Re: Objection to MP08_0244 MOD 1 Modification Request for Mixed Used Development at 23-37 Lindfield Avenue and 11 Havilah Lane, Lindfield

As a resident of Lindfield, I/we wish to lodge an objection against the proposed Modification of the subject development based on the following grounds:

ELEVATIONS

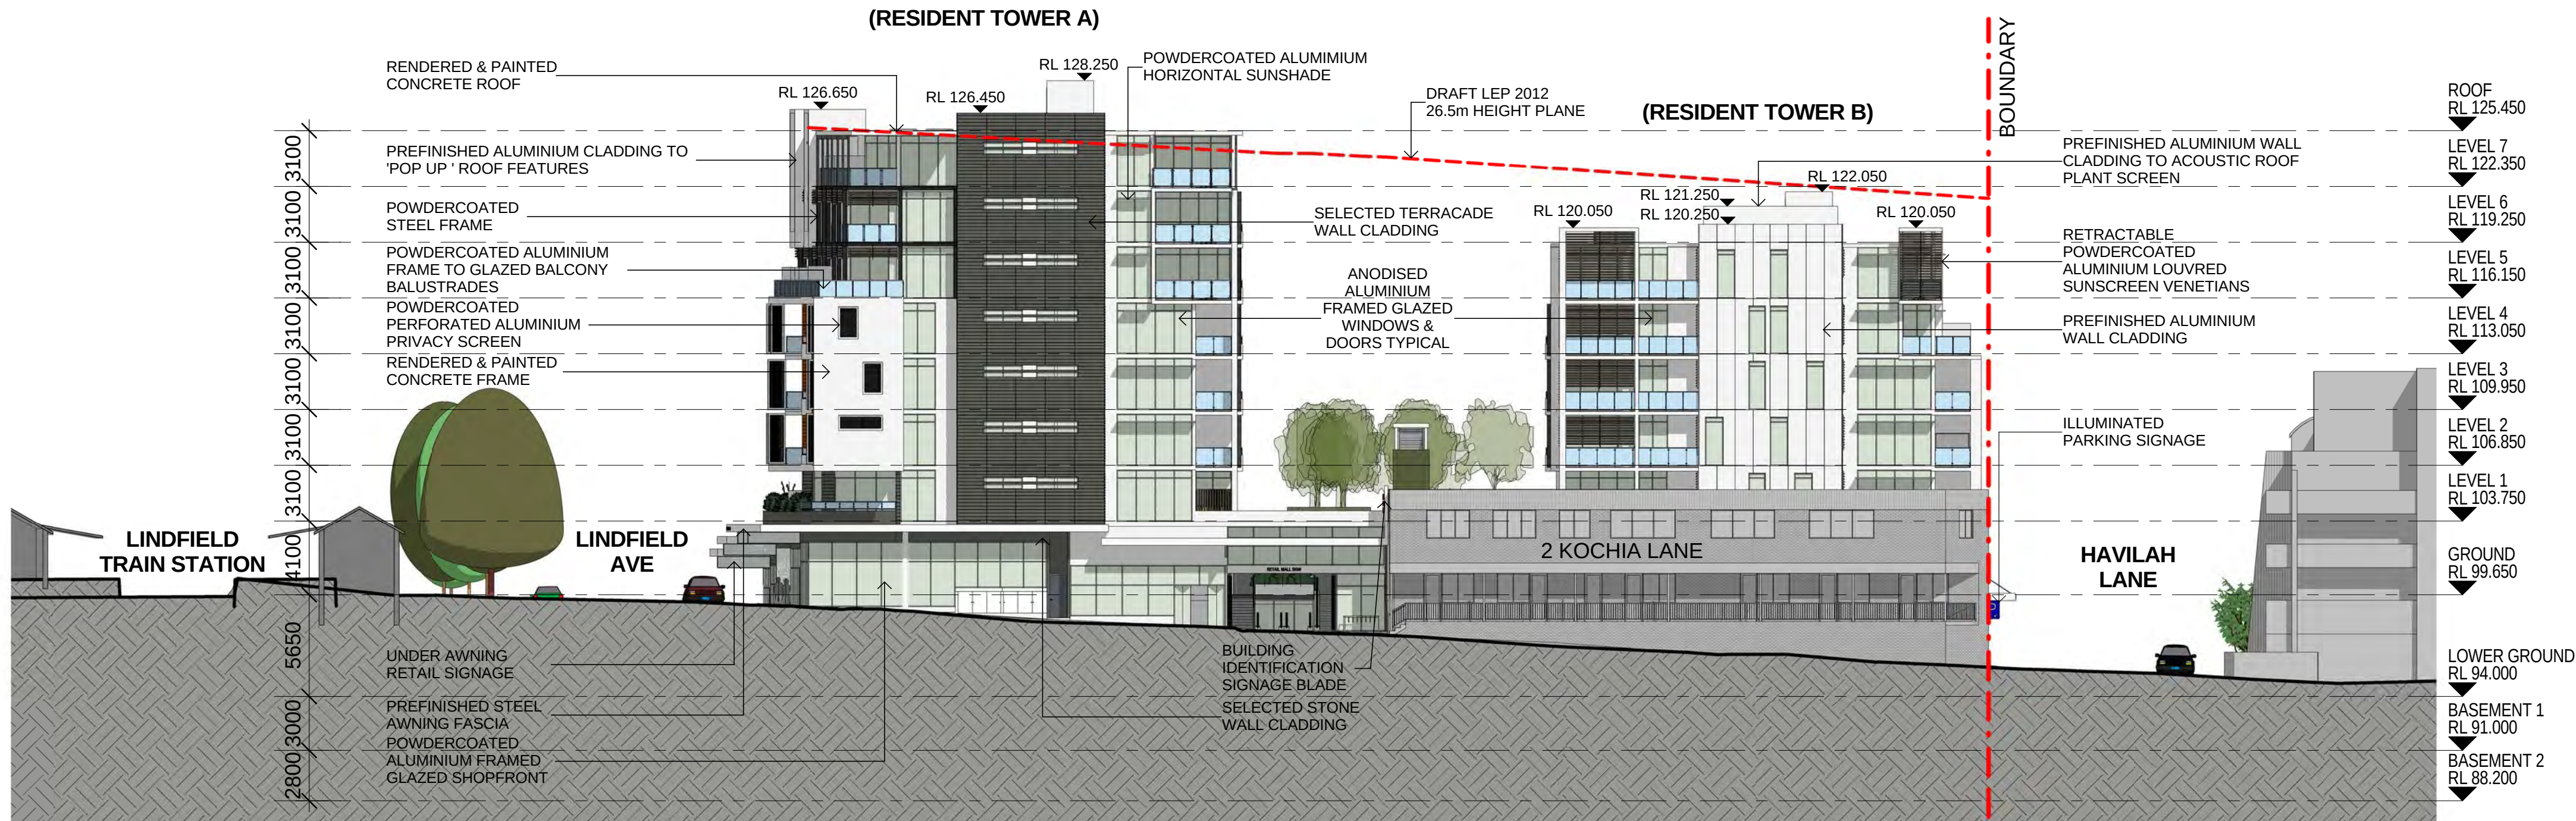
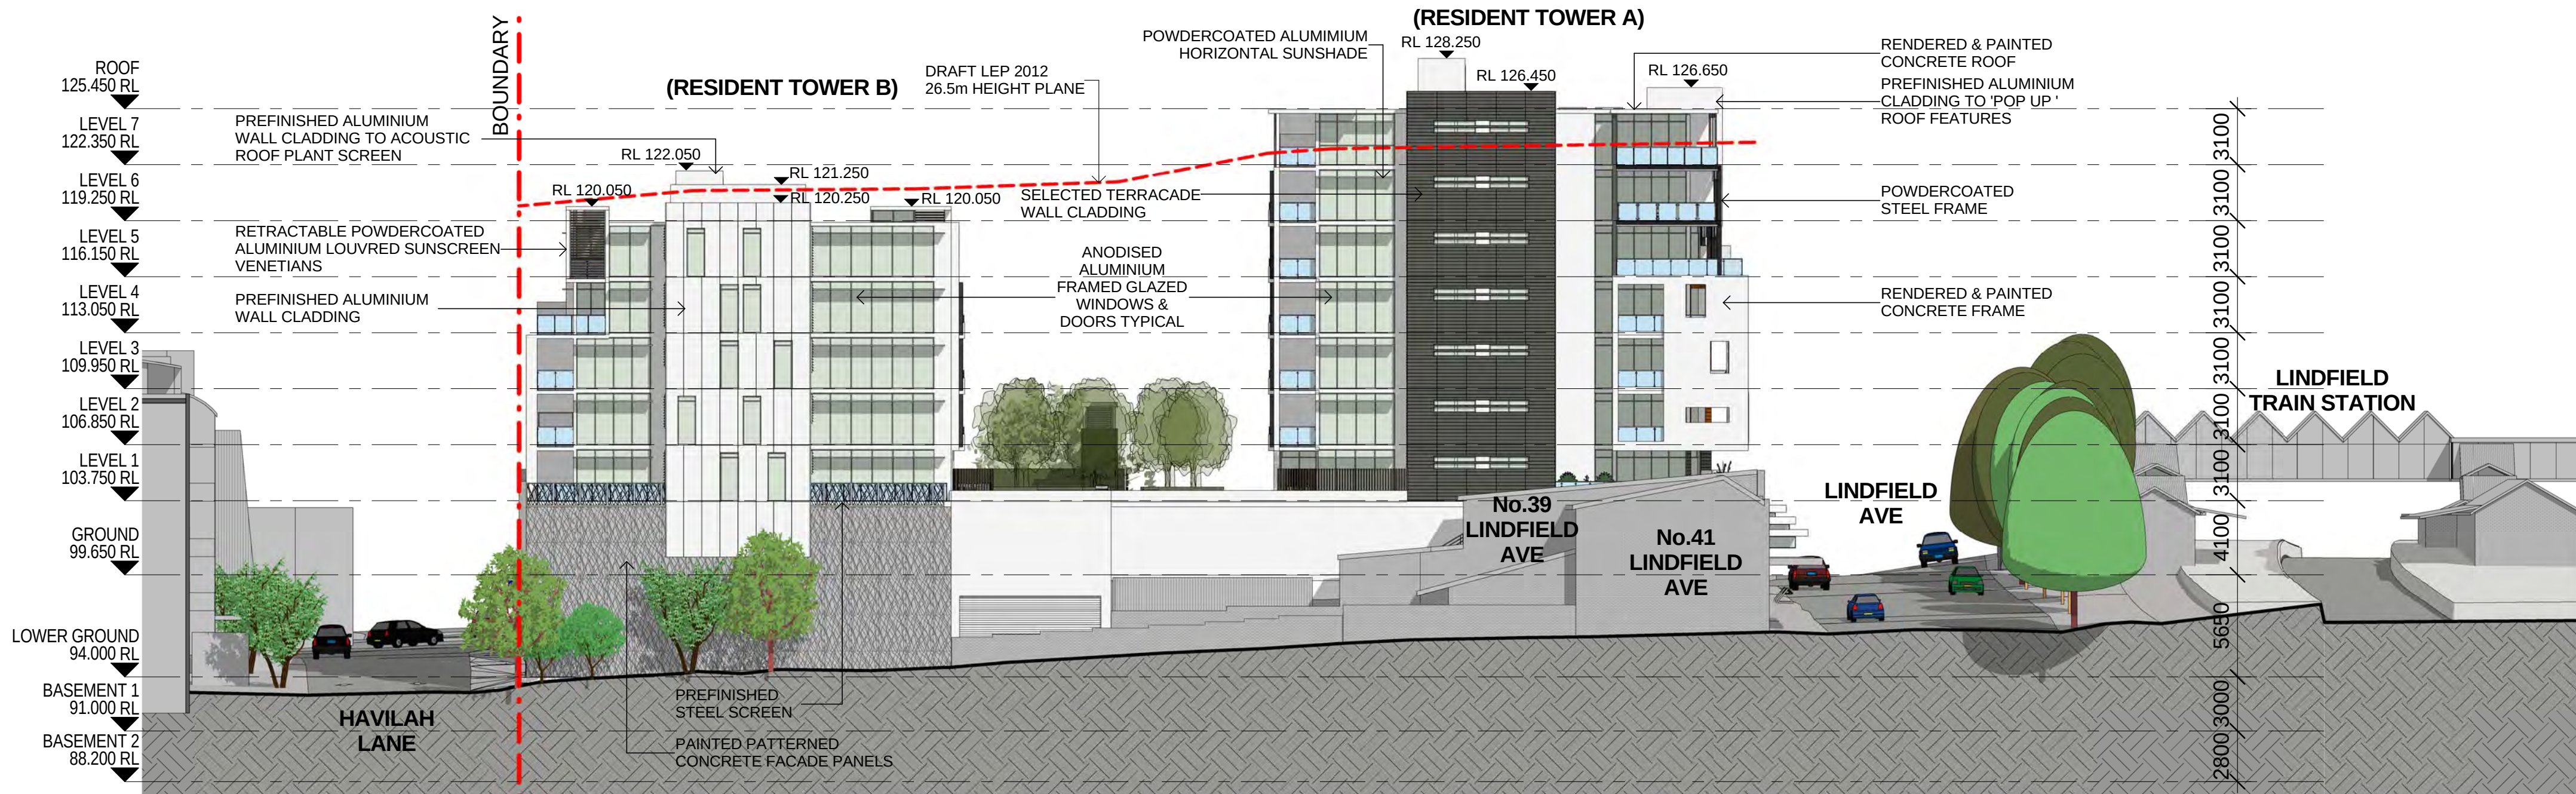
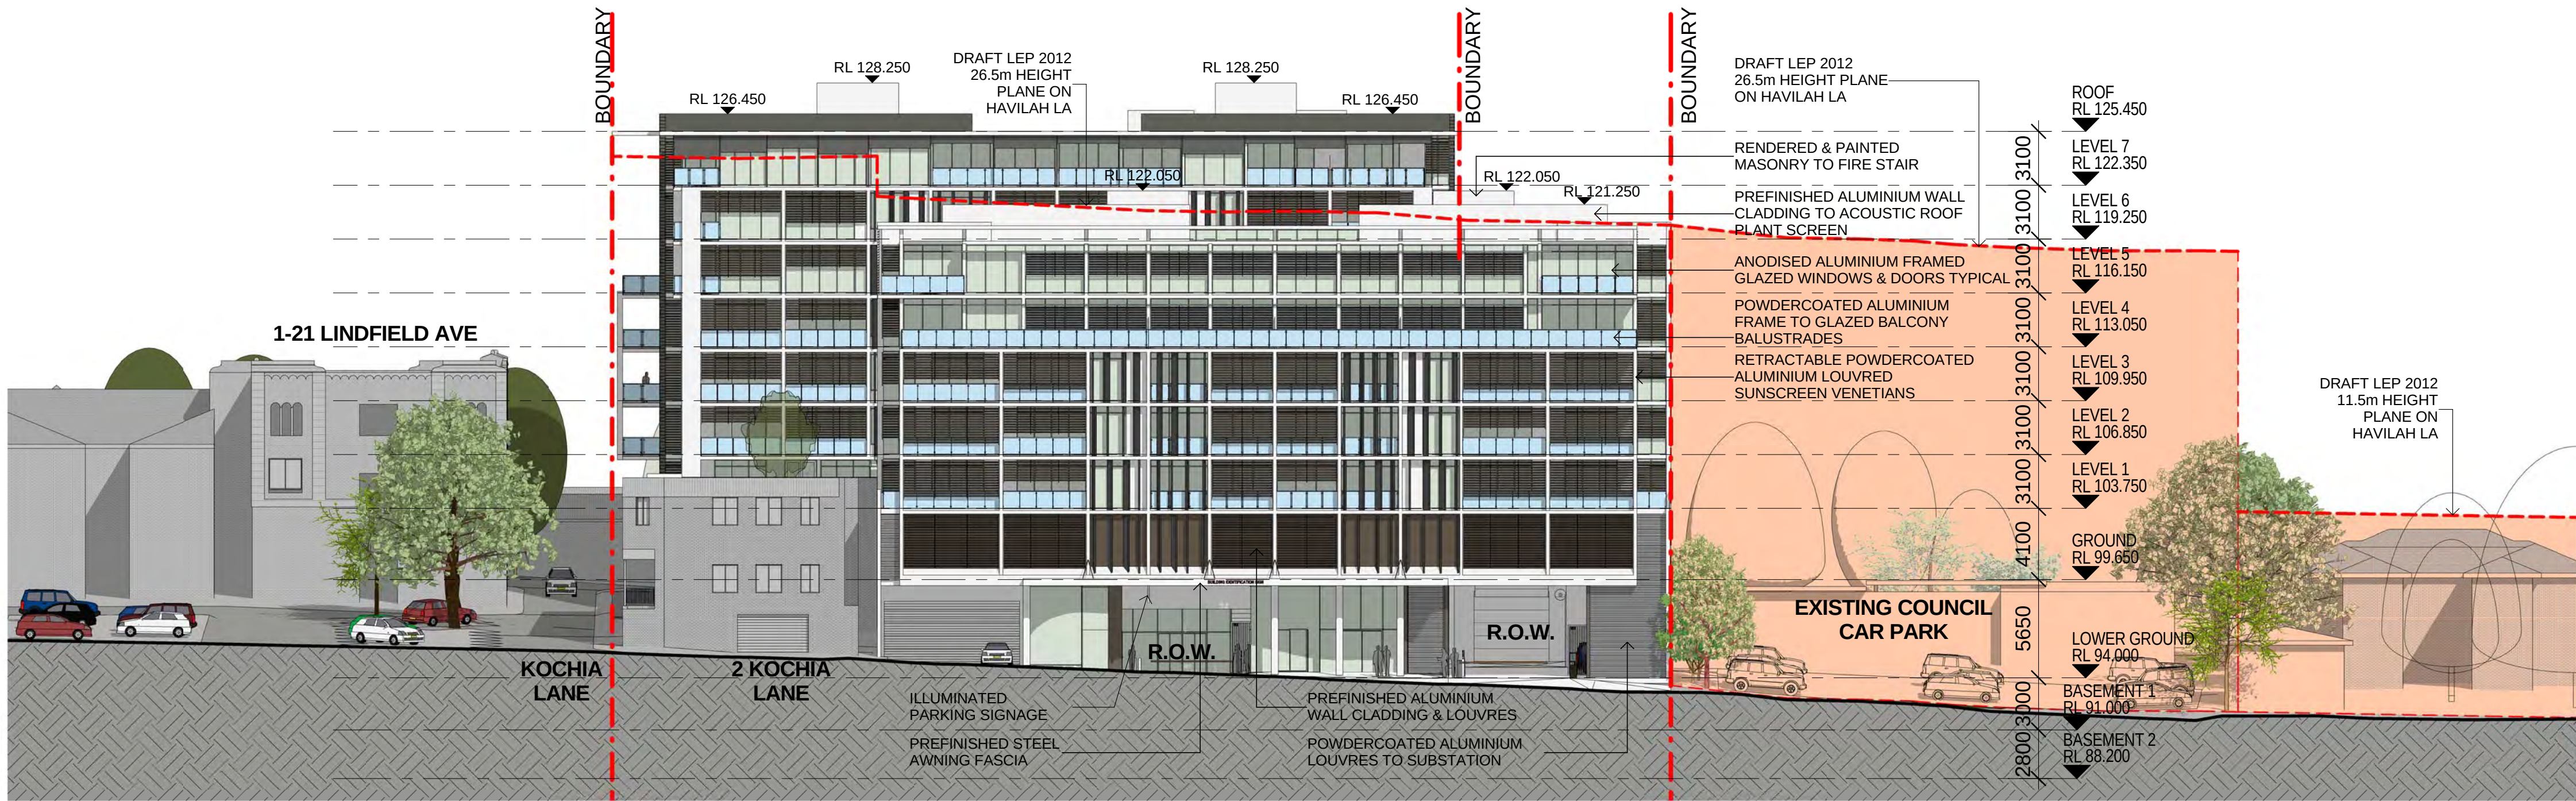
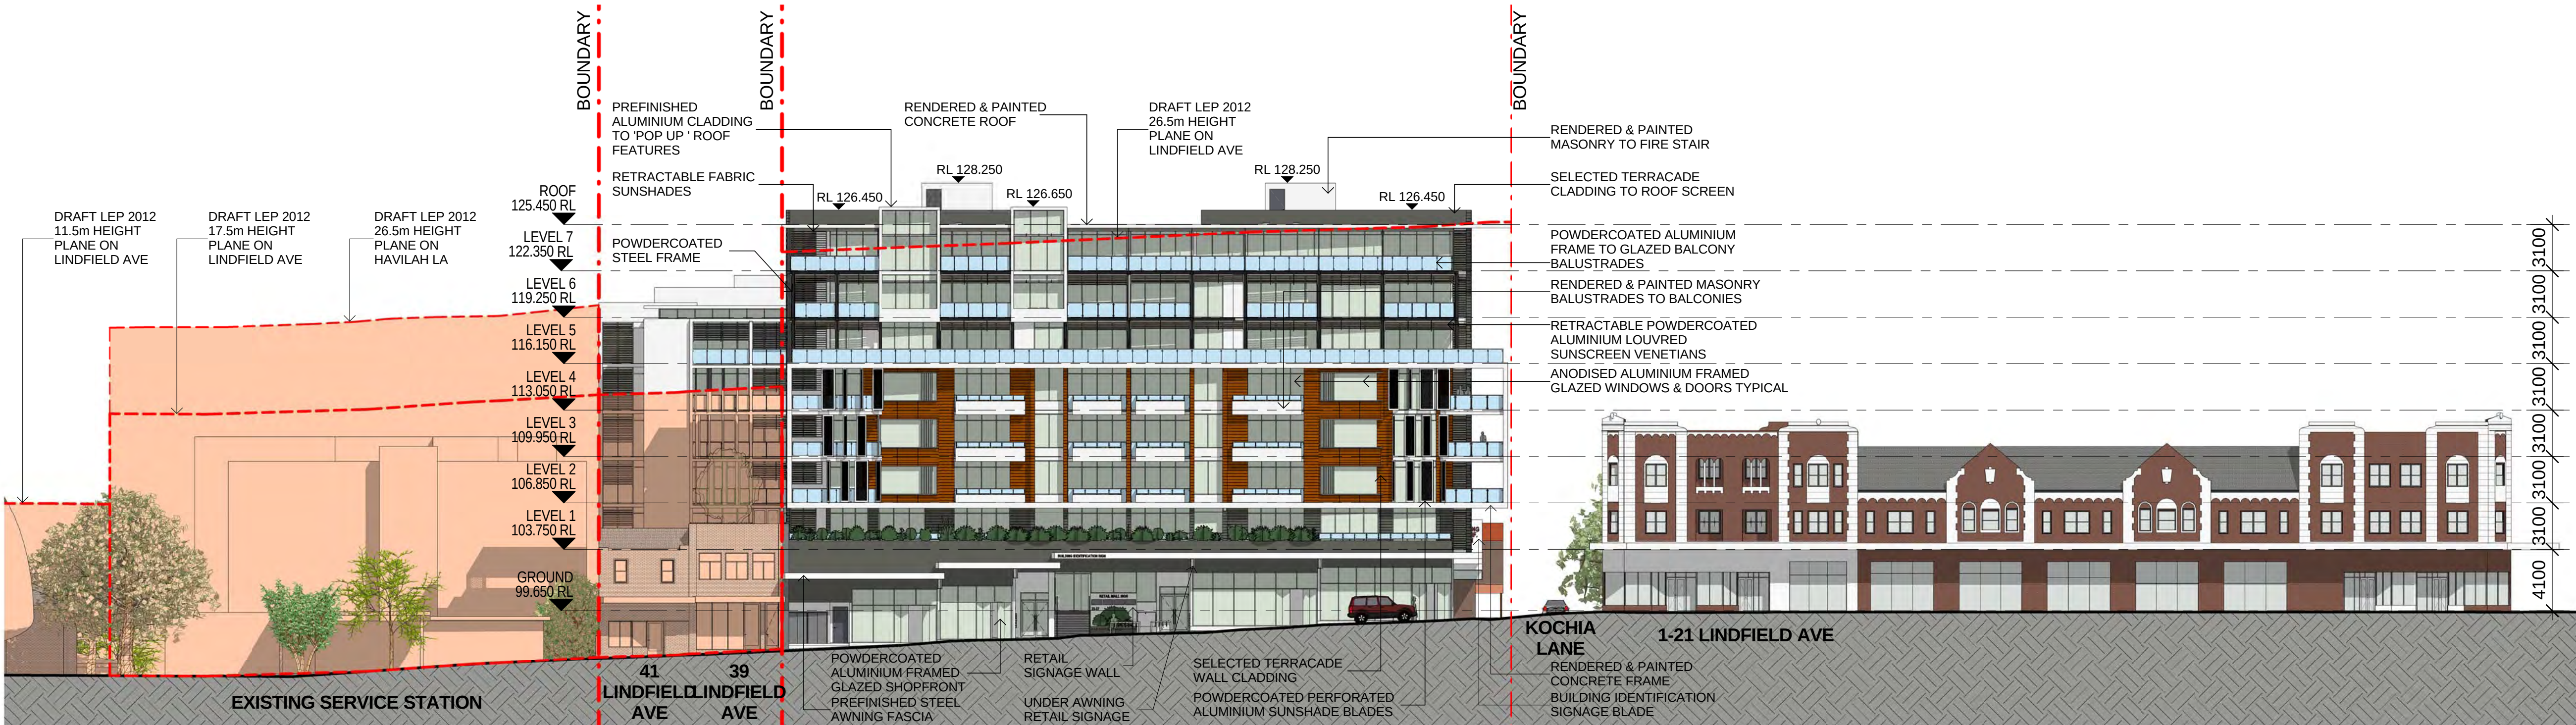
- The increase of an additional storey to both buildings: 8 storeys on Lindfield Avenue and 7 storeys on Havilah Lane creates excessive height and bulk and is out of character with the surrounding buildings, including the heritage listed adjacent building on Lindfield Avenue
